Surveyor's

Affidavit of Correction

On Thursday, August 13th, 2026, I, Danny Rodic, upon oath and under penalty of perjury, dispose and say, as provided in CRS 38-51-111 as follows:

EDUCATIONAL INSTITUTION SUBDIVISION EXEMPTION

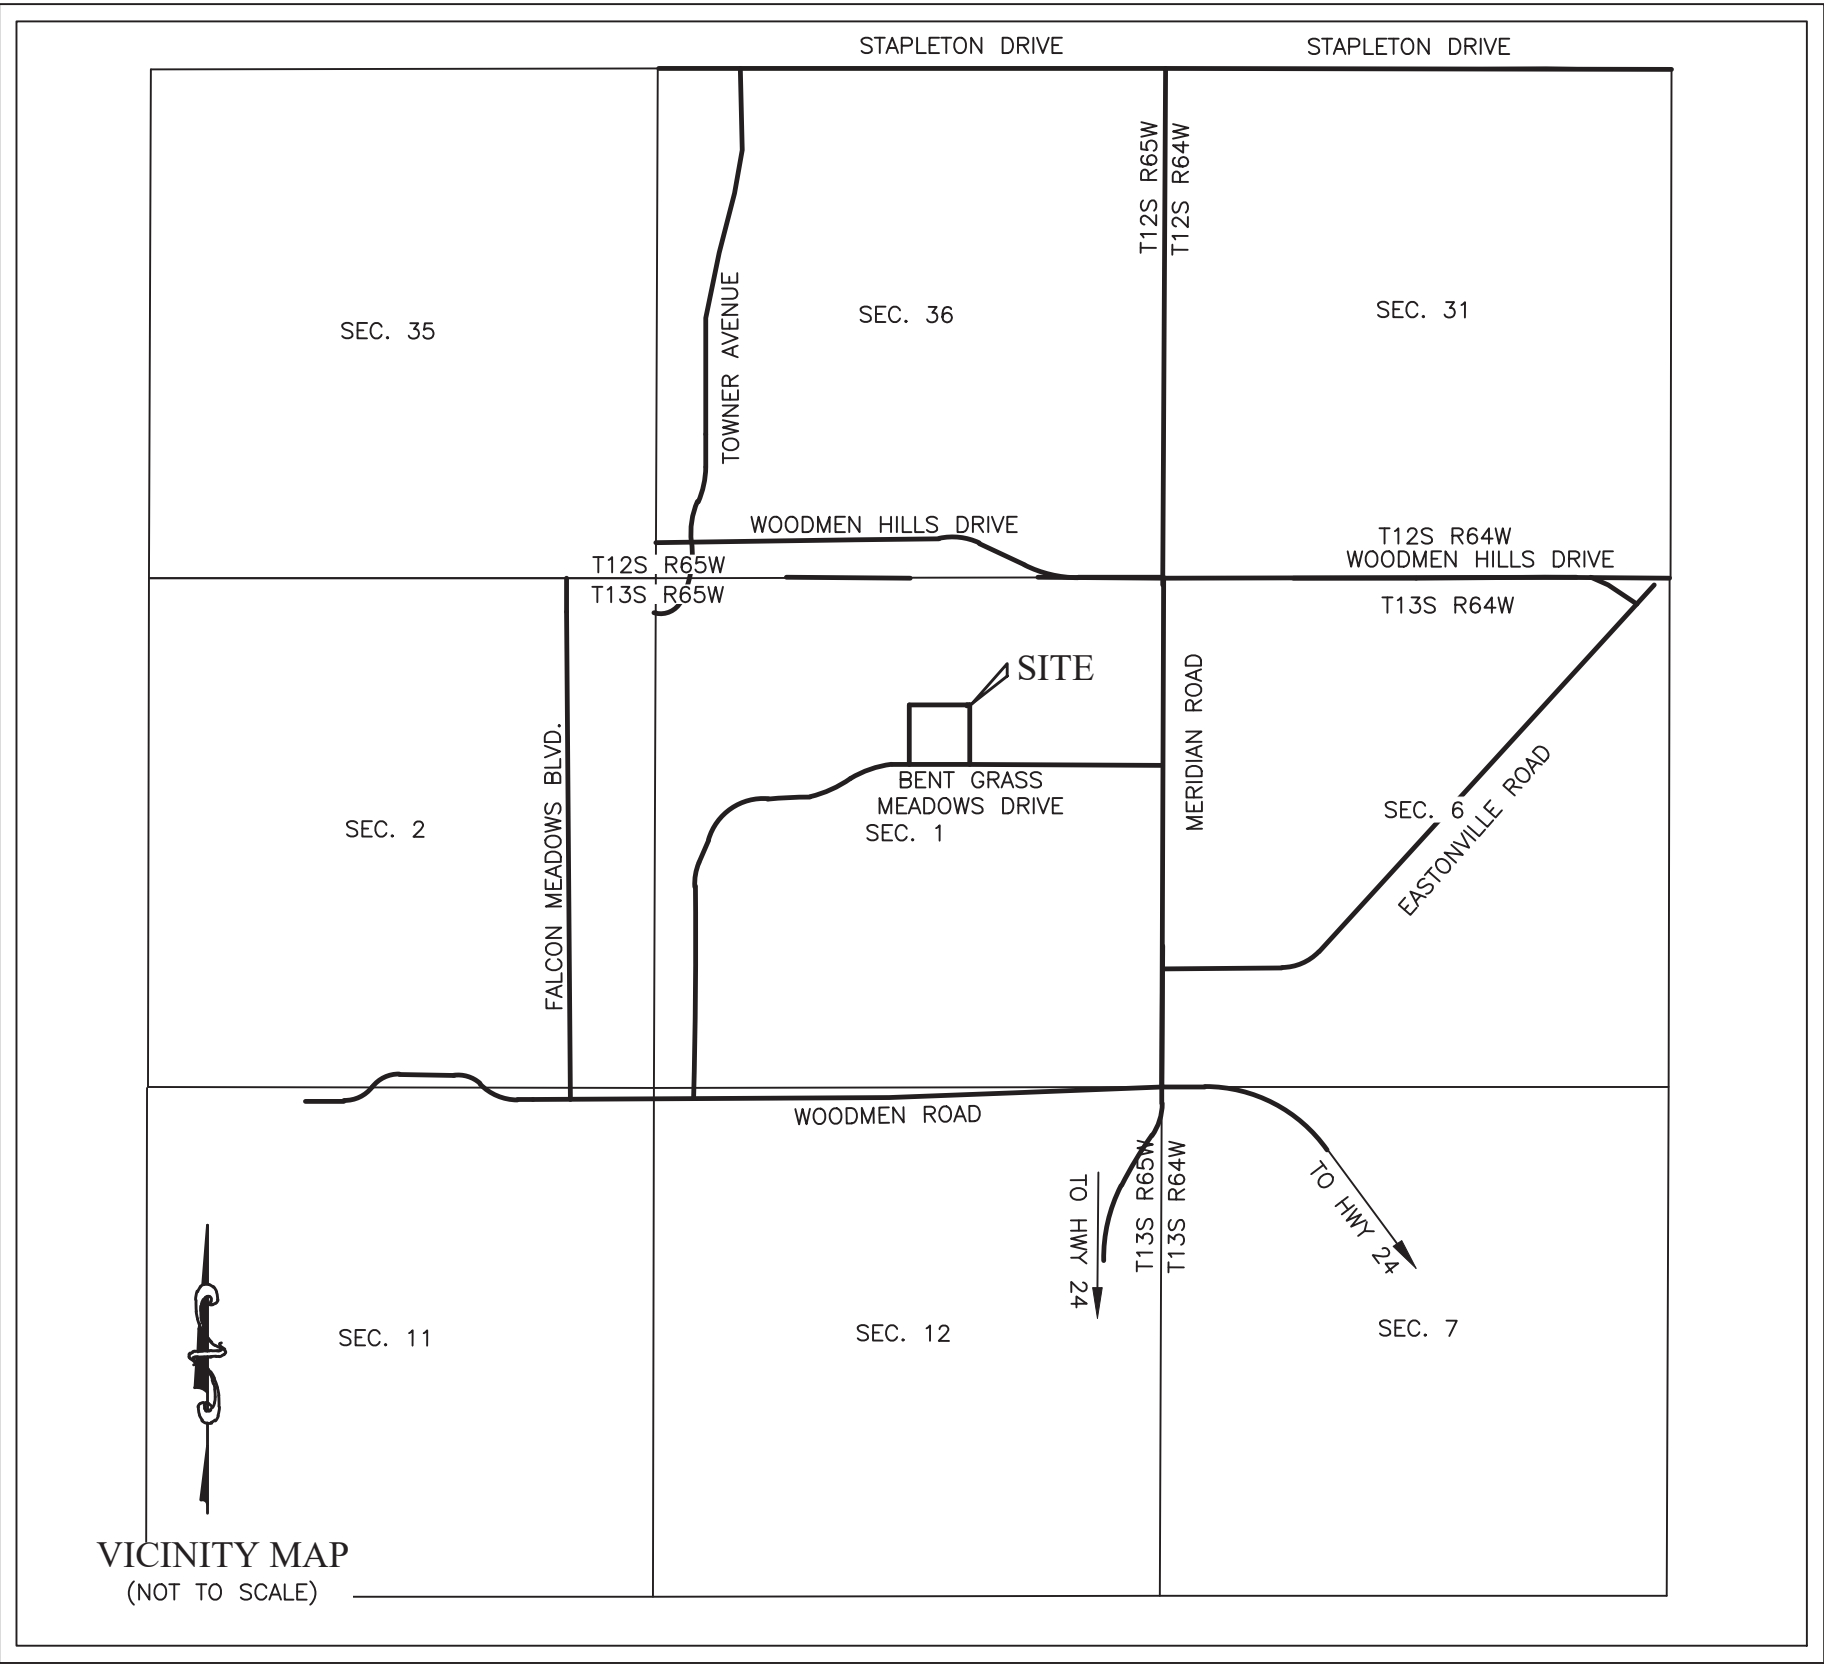
1. I am a Professional Land Surveyor licensed in the State of Colorado as PLS No. 38759.
2. I am familiar with the property described in Exhibit A attached hereto and incorporated herein by this reference (the "Property").
3. I prepared, supervised the preparation of, or reviewed the legal description for the Property that was attached as Exhibit A to El Paso County Resolution No. 26-232, recorded July 24, 2026, under Reception No. 226070444 in the records of the Clerk and Recorder of El Paso County, Colorado.
4. Following recordation, it was determined that the legal description attached as Exhibit A to El Paso County Resolution No. 26-232, recorded July 24, 2026, under Reception No. 226070444 in the records of the Clerk and Recorder of El Paso County, Colorado, contains a scrivener's error in one of the boundary calls.
5. Specifically, the call reading:

THENCE NORTH 89°54'26" WEST ALONG THE NORTHERLY BOUNDARY OF SUBJECT PARCEL...
A DISTANCE OF 631.24 FEET...

And in the 3rd Paragraph, SEC. 1 T.1S. R.65W

THENCE SOUTH 89°54'26" EAST ALONG THE NORTHERLY BOUNDARY OF SUBJECT PARCEL...
A DISTANCE OF 631.24 FEET...

And in the 3rd Paragraph, should be Sec 1, T13S. R. 65W.
